**Application by The North Lincolnshire Green Energy Park Limited for North Lincolnshire Green Energy Park  
The Examining Authority's written questions and requests for information (ExQ1)  
Issued on 23 November 2022**

**Responses are due by Deadline 2, Thursday 15 December 2022**

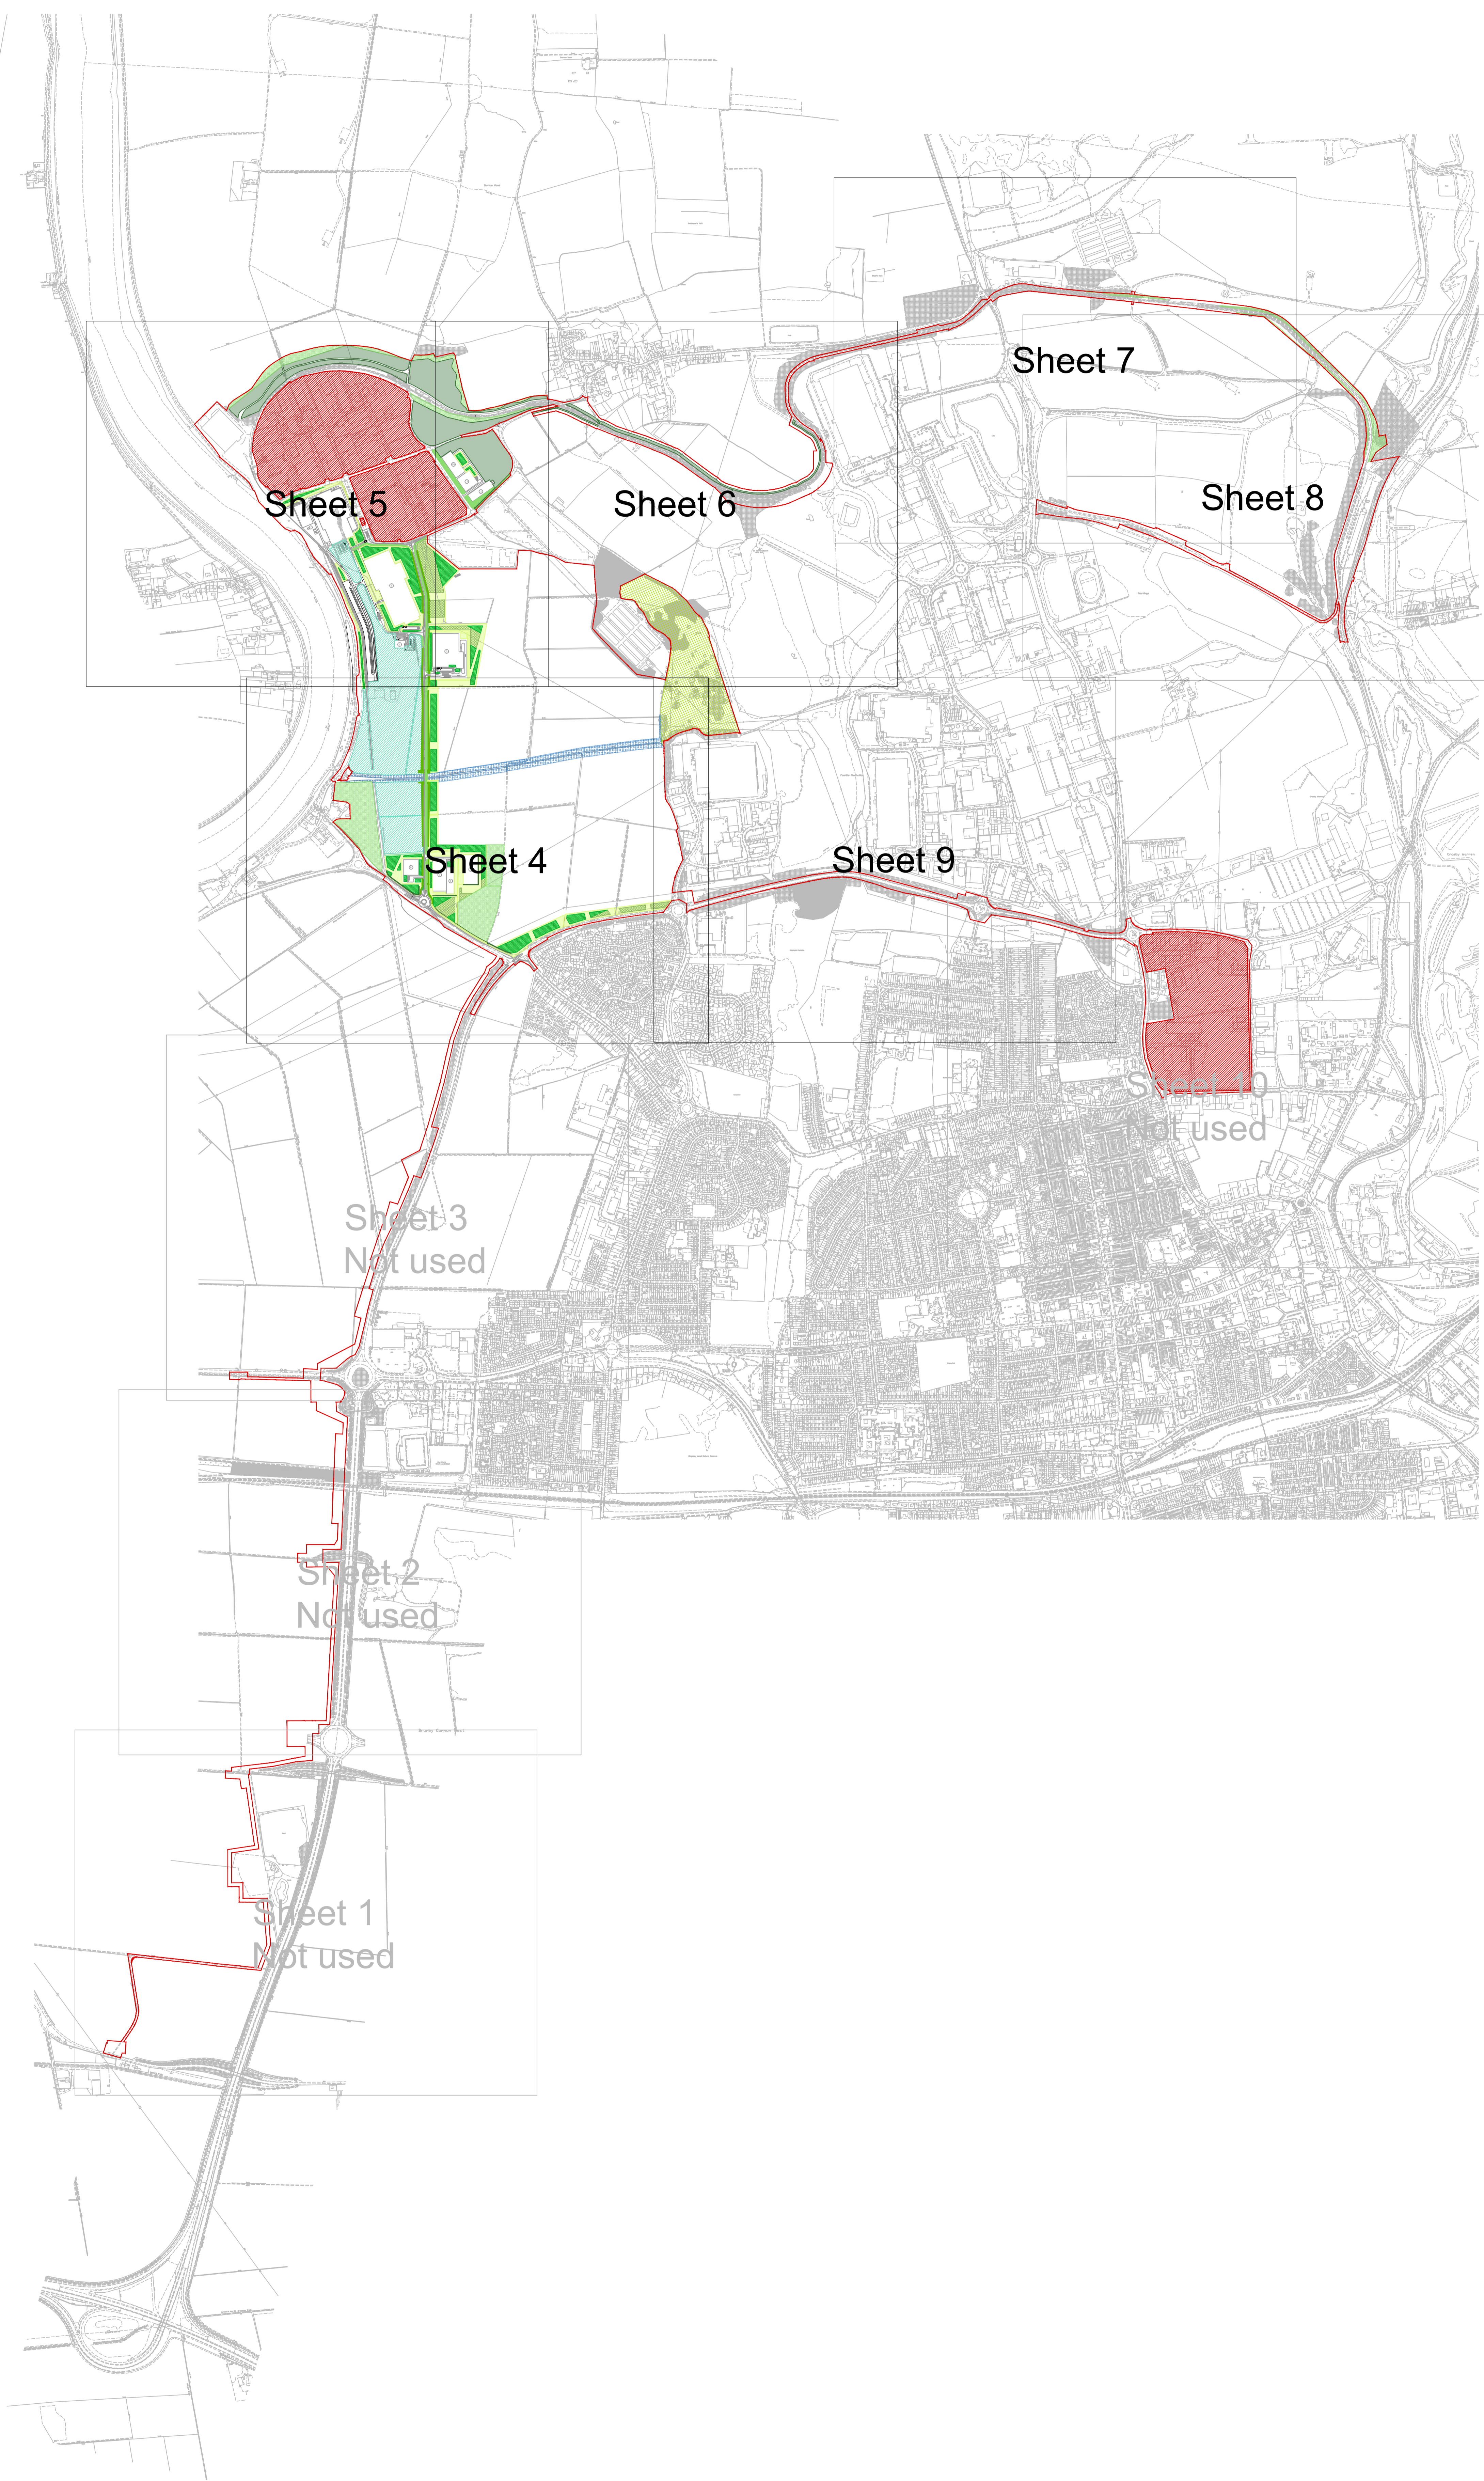
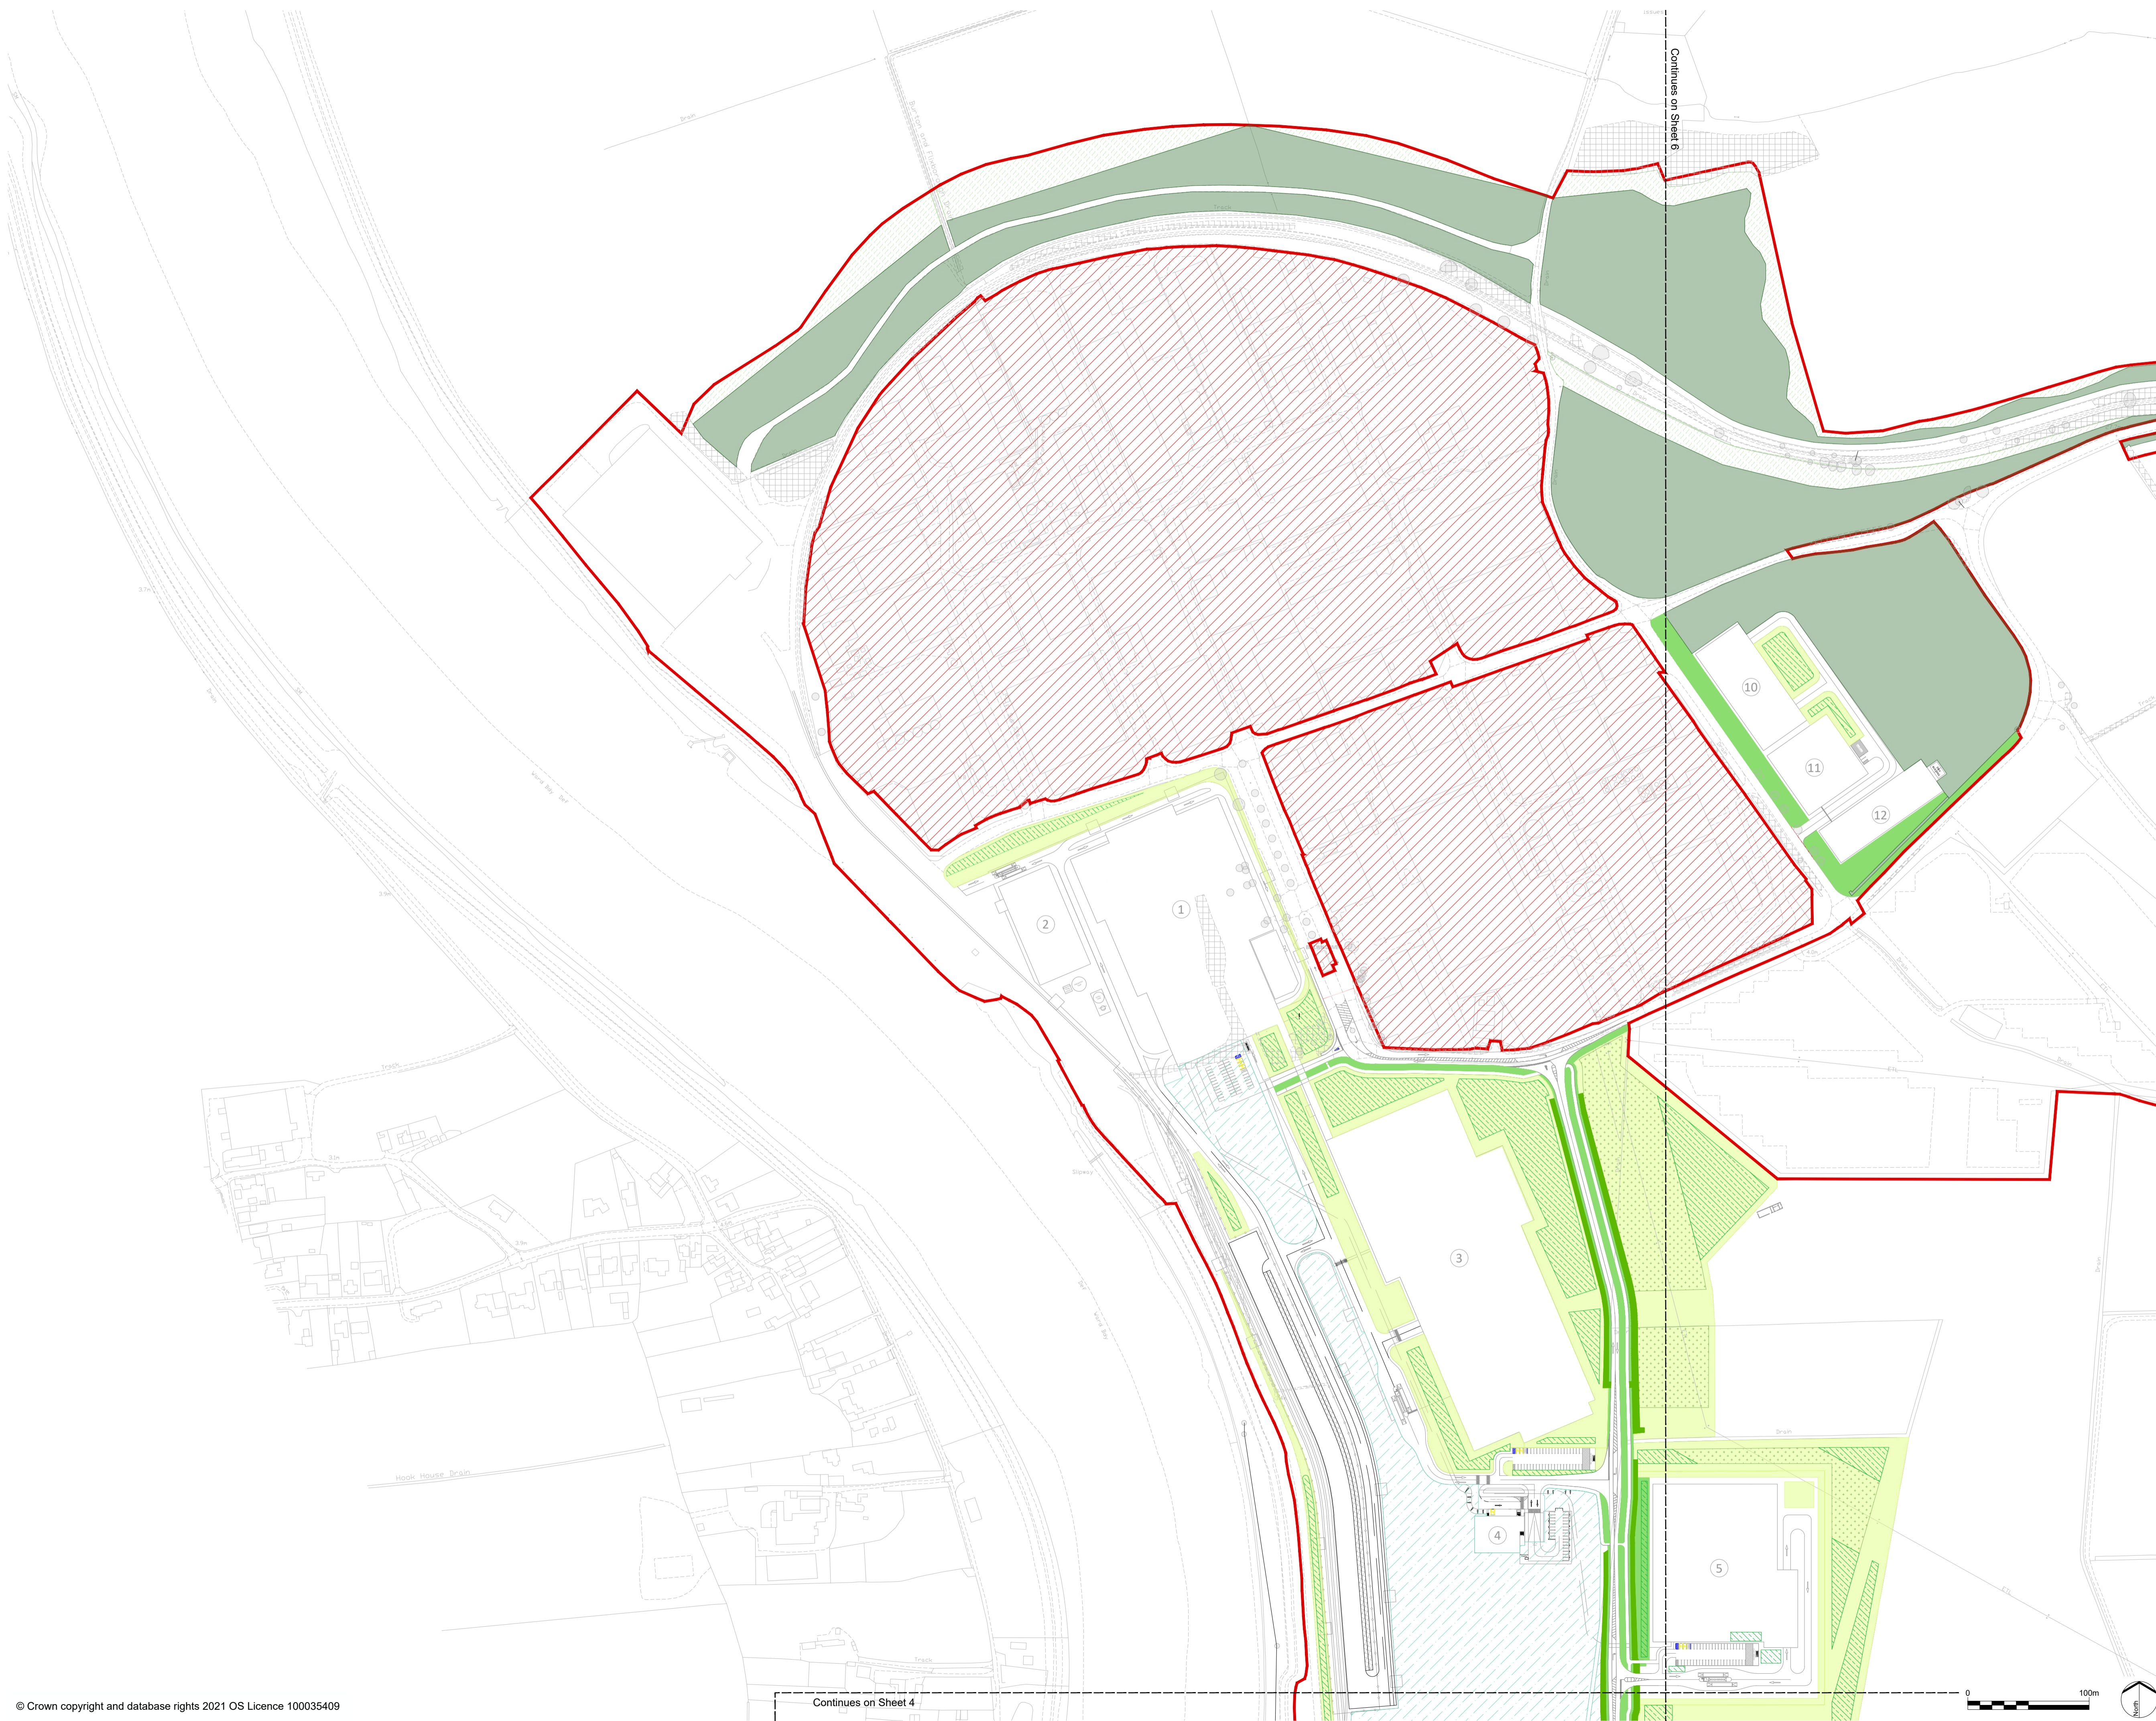
ExQ1	Question to:	Question:
		<p>(i) Can the Applicant confirm what is meant by this term, as the ExA understands from the Outline Landscape and Biodiversity Management and Monitoring Plan (LBMMP) [APP-041] and Indicative Landscape and biodiversity plan [APP-024] that these areas have been set aside for tree planting and an ecological enhancement area.</p>
Q1.0.25	The Applicant	<p><b>Exterior Storage Tanks</b></p> <p>In Chapter 3 [APP-051] at paragraph 3.2.2.25 it states “The facility will also be equipped with a fire water tank, sized to surpass the minimum requirements of NFPA 850”. 7 (National Fire Protection Agency)</p> <p>(i) How is this secured within the DCO?</p> <p>(ii) How much larger than the minimum requirements will this be, in answering this please provide a volume and percentage and a justification for this approach.</p>
Q1.0.26	Applicant	<p><b>Health</b></p> <p>With respect to APP-065 ES Chapter 17 Health</p> <p>(i) Please could the assertions at 6.5, including 6.5.1.5, be amended to provide a clear set of conclusions with the respect to the operation of all the processing plant, including (but not limited to) that required for the incineration of waste and that required for carbon capture plant drawn from the Human Health Risk Assessment presented in Appendix B?</p> <p>(ii) Within Appendix B the final risk assessment values are compared favourably with those ‘conventionally considered to be acceptable for industrial regulation in the UK’ Please could the source be included and explained, or a reference provided within the submissions where this can be found?</p>
